Developer Services
Southern Water
Sparrowgrove House
Sparrowgrove
Otterbourne
Hampshire
SO21 2SW

Your Ref
A/146/18/PL
Our Ref
PLAN-026698
Date
18/02/2019

Proposal: Construction of new semi-detached dwelling extending existing terrace of cottages.
Site: Land adjacent to 4 Gladstone Cottages, Water Lane, Angmering, BN16 4EL.
A/146/18/PL

Client	SOUTH NUTFIELD PROPERTIES			Scale	1:100 @ A3
Job Title	4 GLADSTONE COTTS ANGMERING BN16 4EL			Date	November 2016
Drg. Title	PROPOSED SEWER DIVERSION			Drg. No.	161101 / 2
				Rev.	C

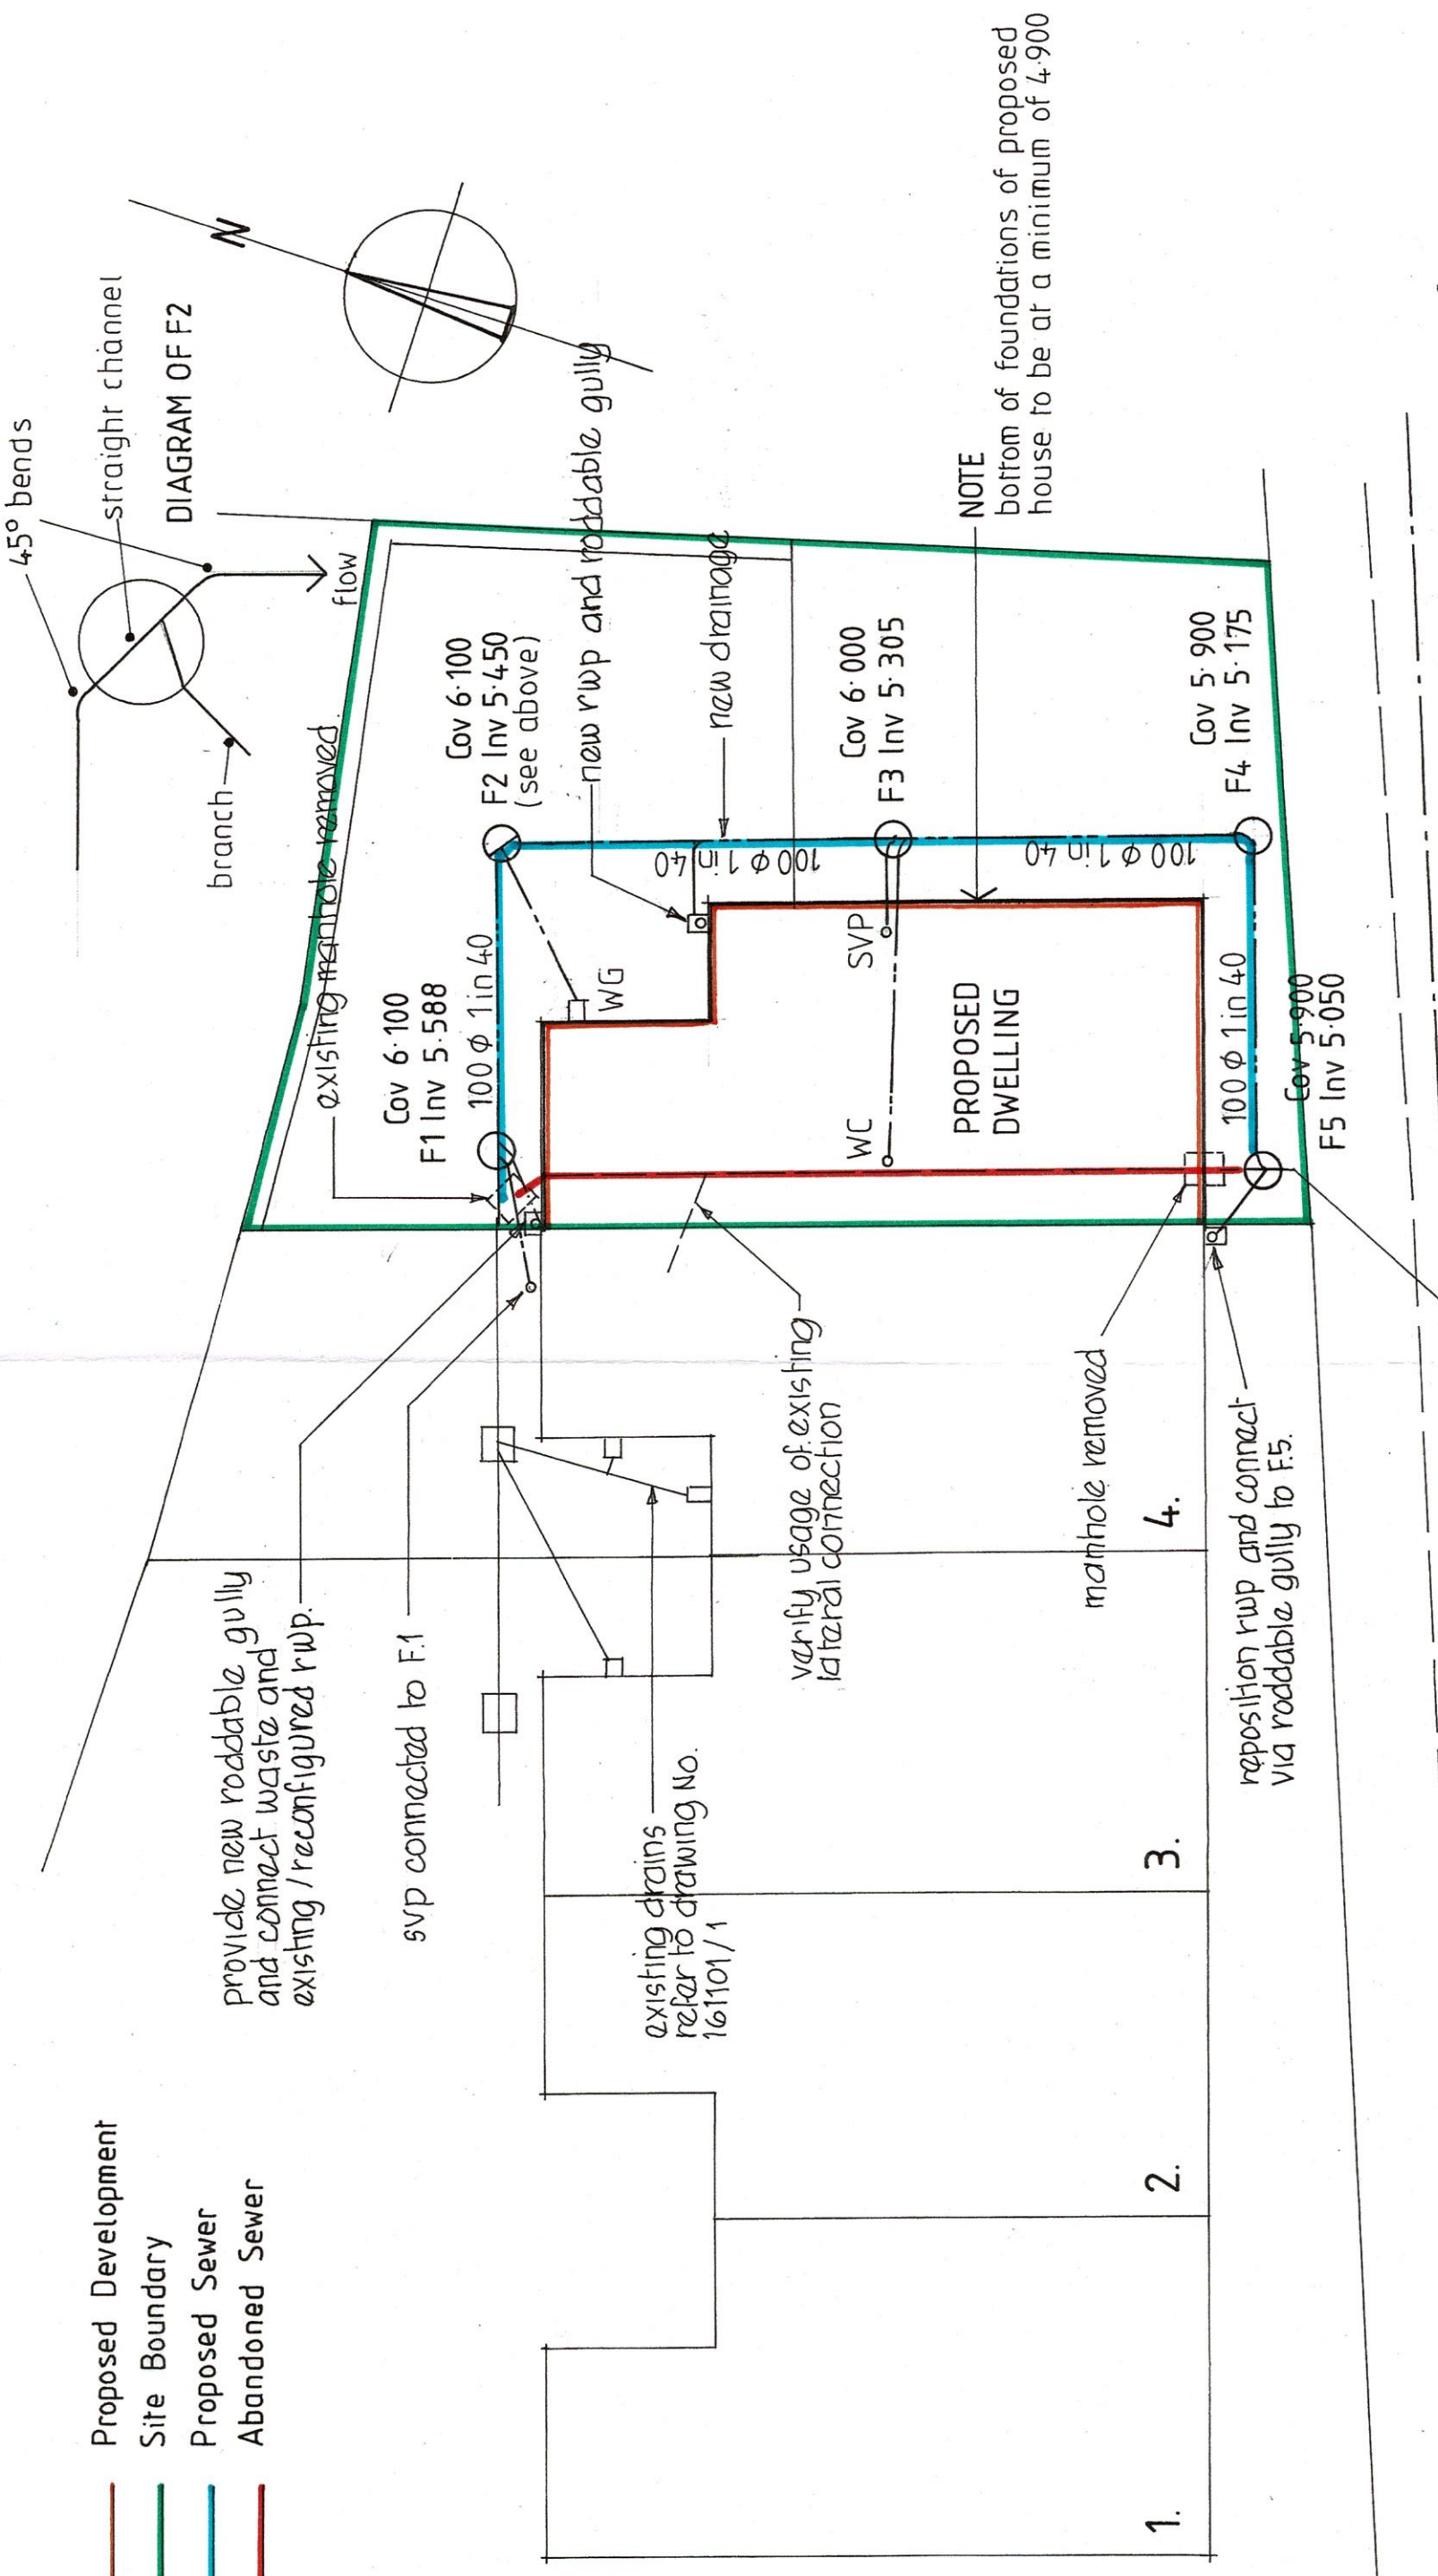
Please note on the attached plan, there is a public foul sewer within the site. The diversion of public foul sewer shall be carried out in accordance with details as approved by Southern Water under Section 185 of the Water Industry Act application process.
